Re: Letter of Intent: Administrative Relief for Permit # L01557

3690 Pronghorn Meadows Circle

# SITE PLAN

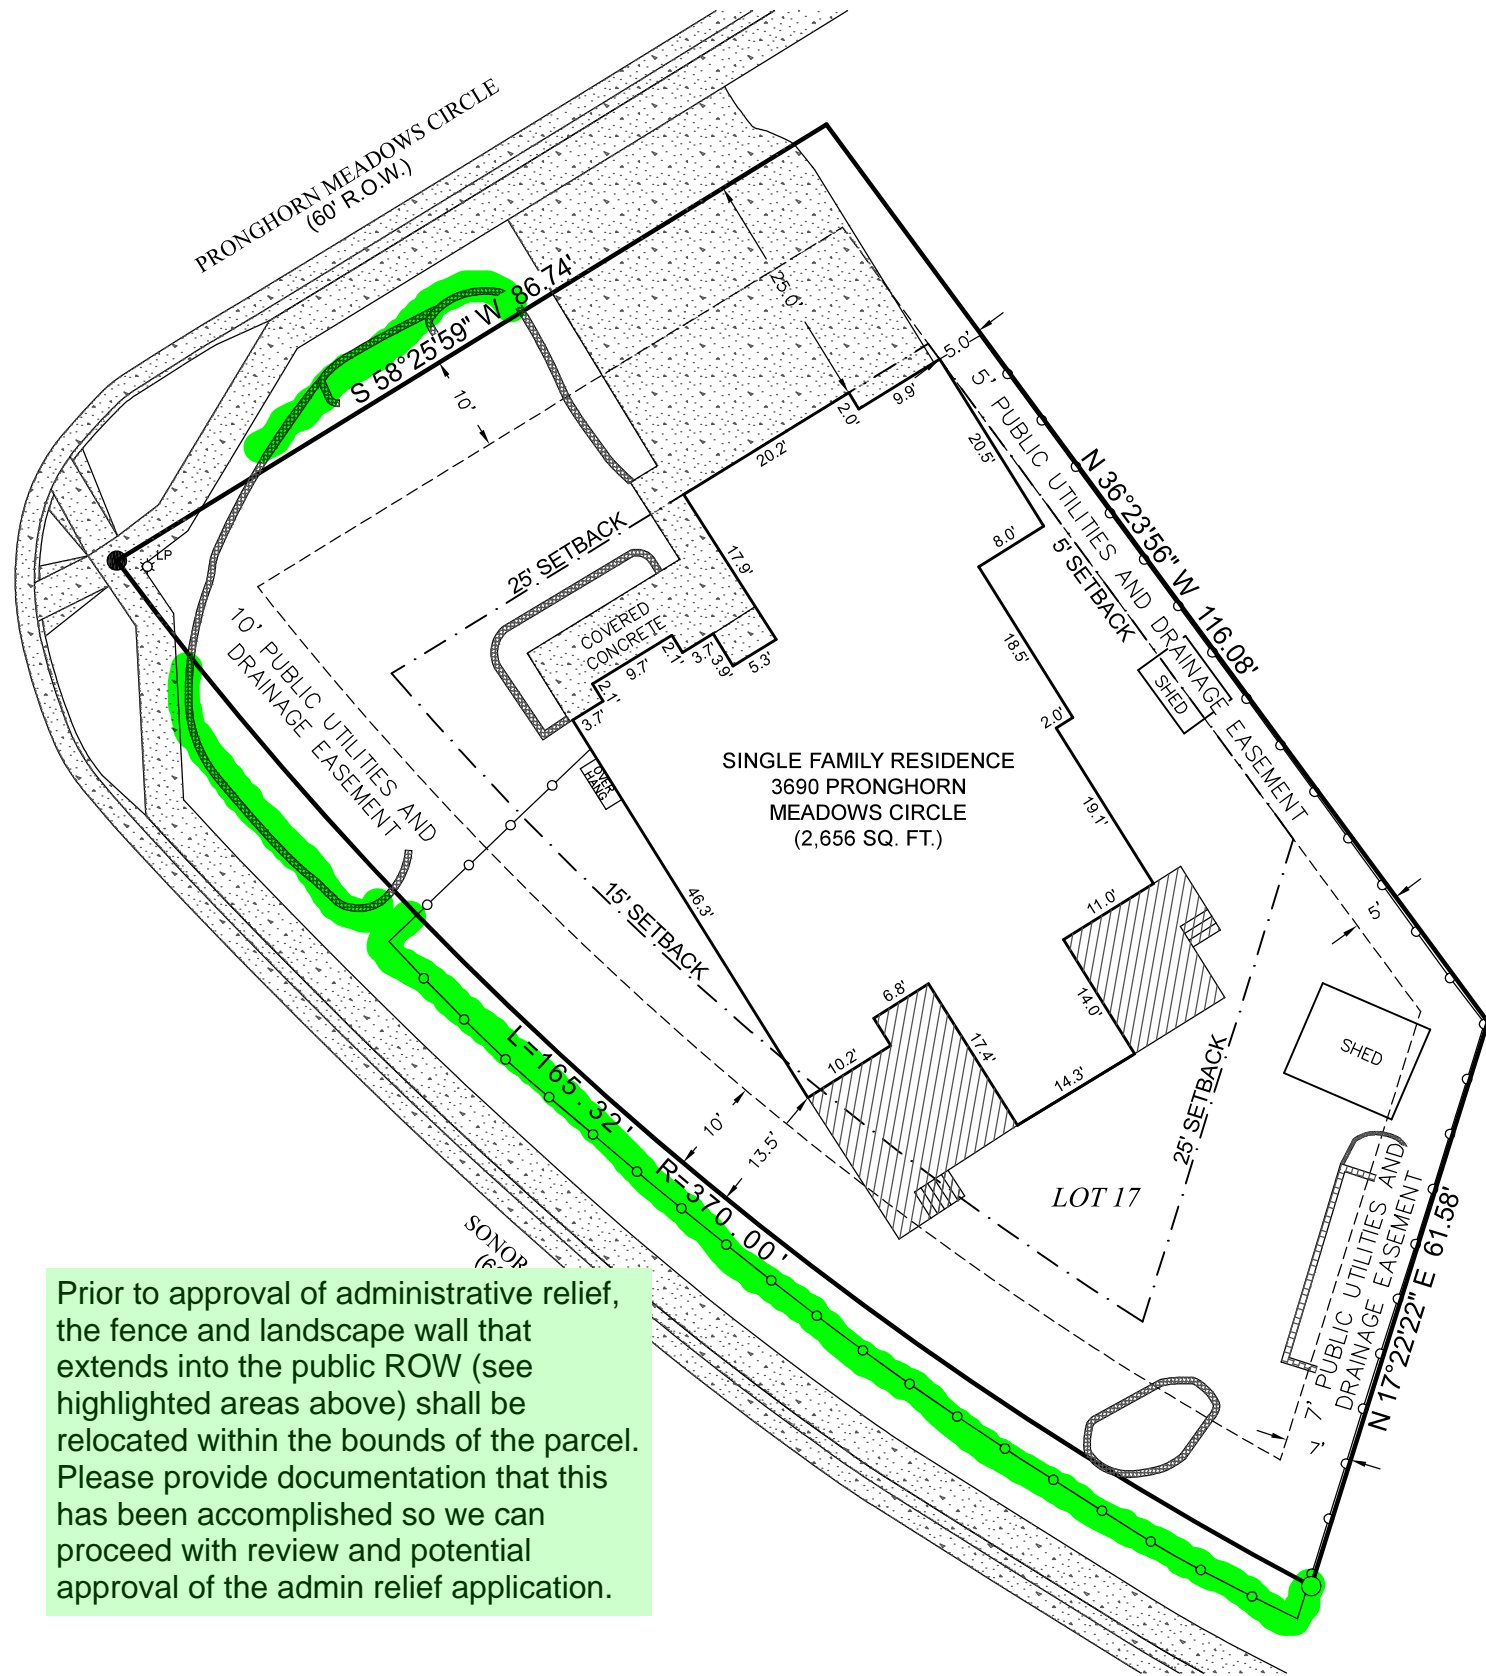
In the letter of intent, mention the fence and landscape wall that has been constructed off the parcel and indicate that it has been relocated on the parcel. We will need to see an exhibit showing this prior to consideration of the admin relief for the deck and addition.
